Response to Submissions Report

State Significant Development – SSD 18_9095

Armidale High School Redevelopment

Butler Street, Armidale

This prominent distant view will not be obscured by the new ASC design and will be enhanced through the removal of Building G.

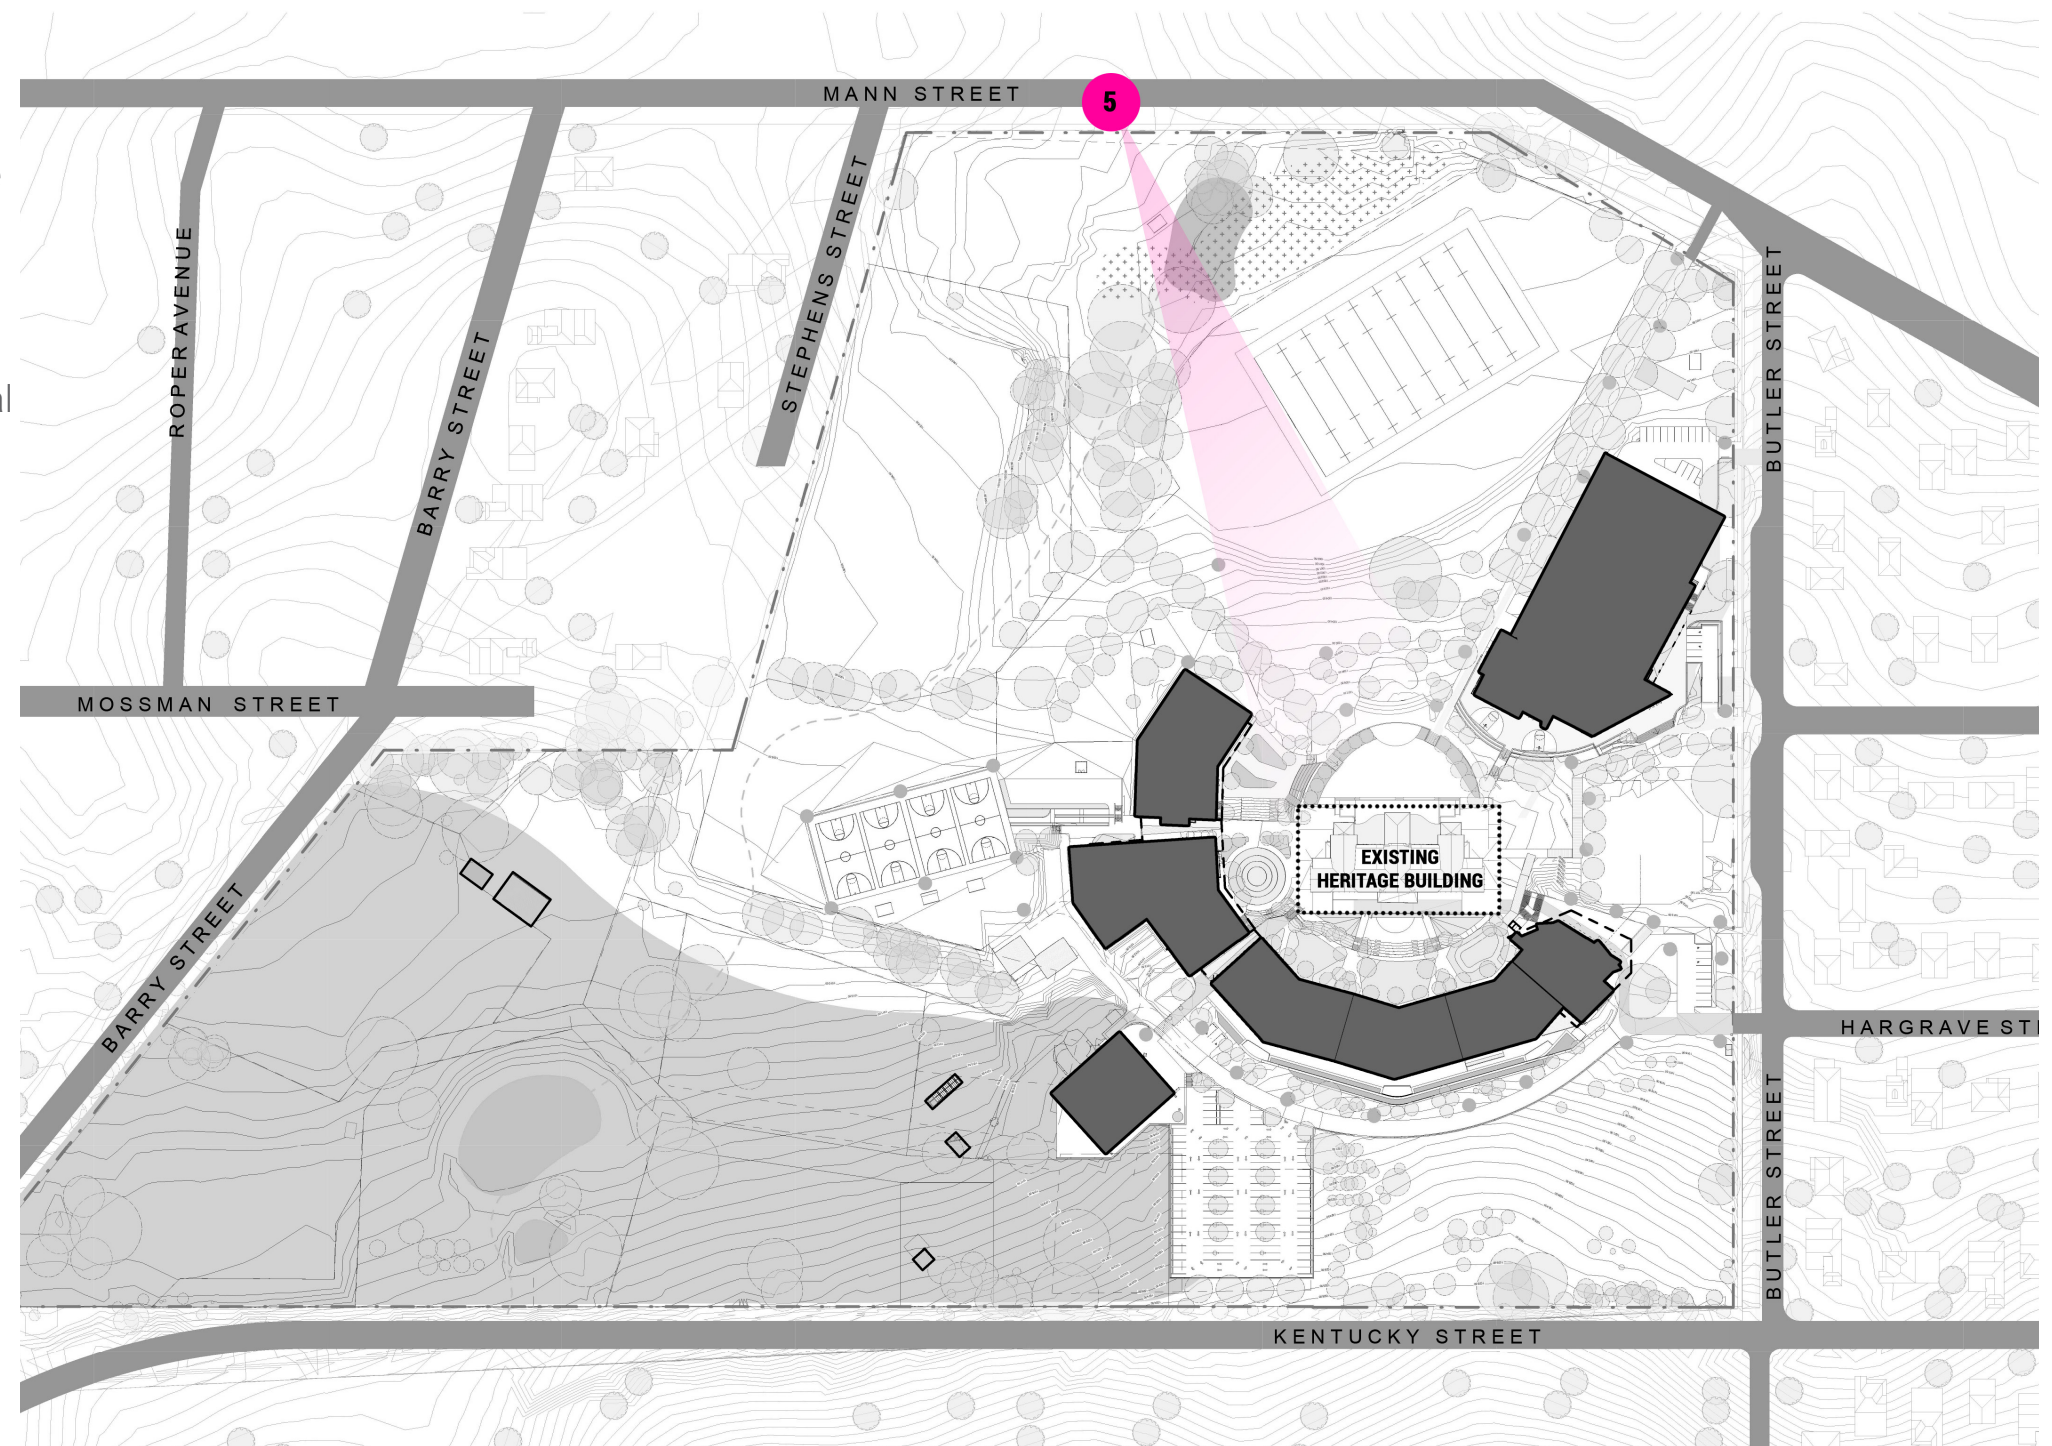
7. While it is acknowledged the Council did not raise concerns with regard to the proposed development, the Heritage Council has raised concern with regard to the impact of the proposal on significant views to the locally listed heritage item. Additional information is required addressing the impact of the proposal on the significant views.	The View Analysis provided as part of the original DA submission (refer Appendix 16 of the EIS) has been updated to provide additional information, including: - Comparison between existing and proposed views at significant viewpoints around the site; - Demonstration as to how these views would be maintained with the construction of the proposed buildings; and - Consideration of the impact the proposed buildings would have on significant views, including potential improvement to views or prominence of visual settings within the site. Further, it is noted that the design change to accommodate air conditioning (resulting in an increase in building height by 300mm) has been incorporated into the expanded View Analysis.	View Analysis Appendix 2
